Our ref: HMS Application No 1444

Notice of Exhibition of application for MOD 2, Proposed design modifications (SSD-10384 - Mod-2)

It is noted that this modification application follows a State Significant Development Approval that was issued for the alterations and additions to the Sirius building including 'restoration and refurbishment for a mixed-use development' on 18 June 2021.

4 40G - DETAIL - SECTION - WINDOW SILL - TO EXISTING PRECAST NOSING
1:5

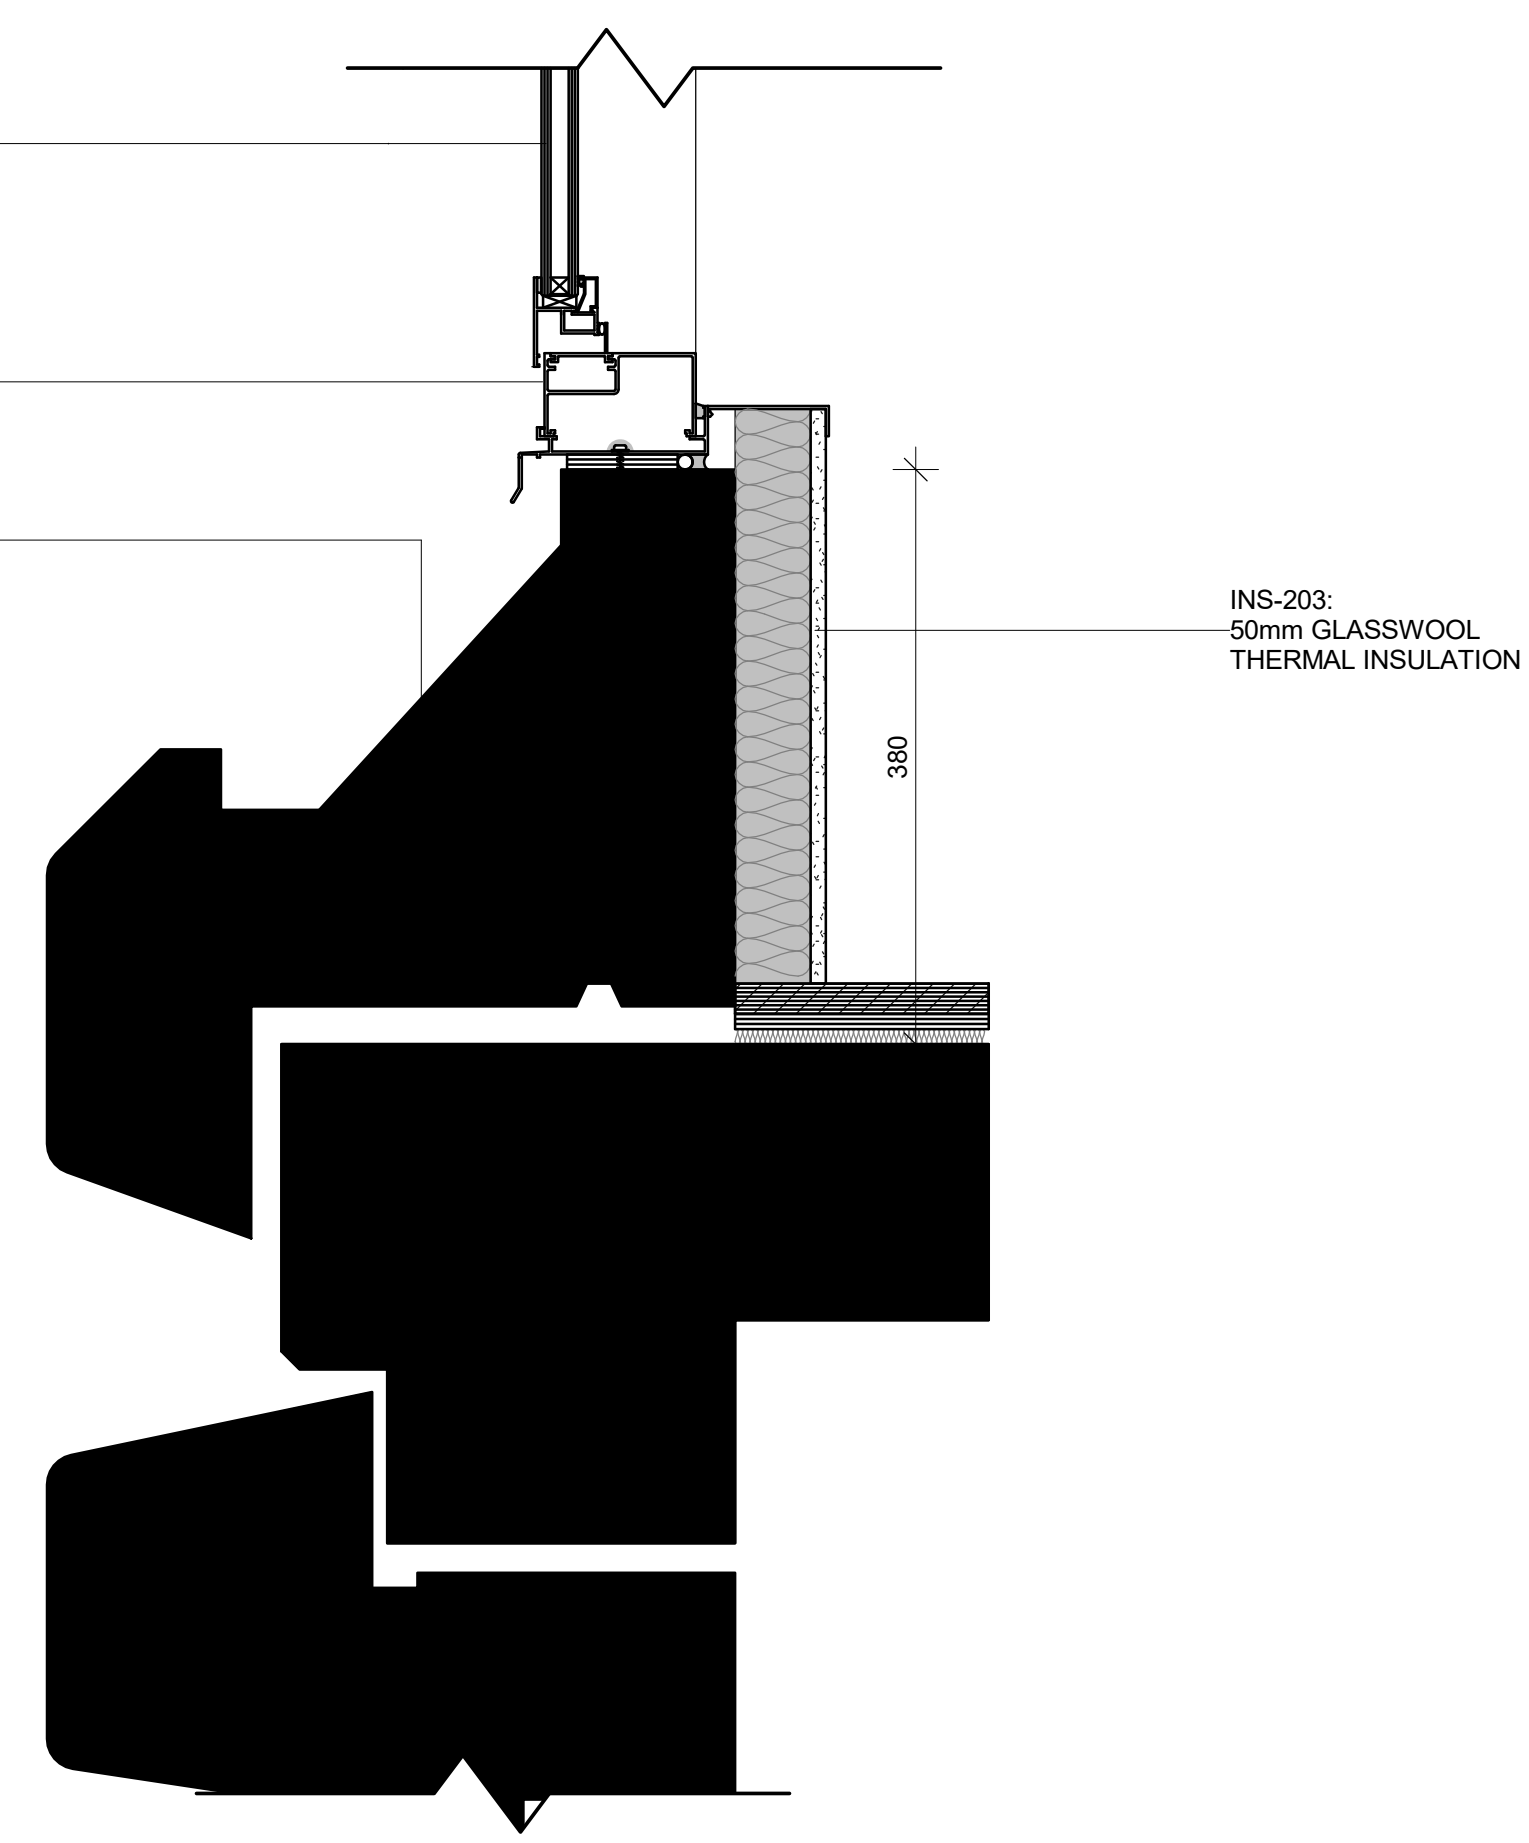
Modification to approved balconies would have some impact on the character and presentation of the building. It is, however, noted the changes are needed to comply with current NCC requirements for hydraulic drainage and climbability/safety.

Following consultation with Heritage NSW, the applicant has agreed to retain and reuse existing metal balustrades to the six terraces as noted in the attached drawing (Attachment A). On balance, the changes to the approved balconies on upper levels to replace metal balustrade with glazed balustrade (as highlighted in yellow in Attachment A) is considered acceptable.

It is further noted the treatment of balconies (highlighted in blue) at the lower levels vary from those highlighted in yellow and feature punched windows without any balustrades. The rationale for the inconsistent treatment is not clearly explained in the submitted documentation. It is considered that a more consistent treatment across all affected balconies (as highlighted in blue and yellow) would have a better outcome. This would also align better with the intent of the approved SSD that features consistent treatment to balconies with balustrades on all these levels.
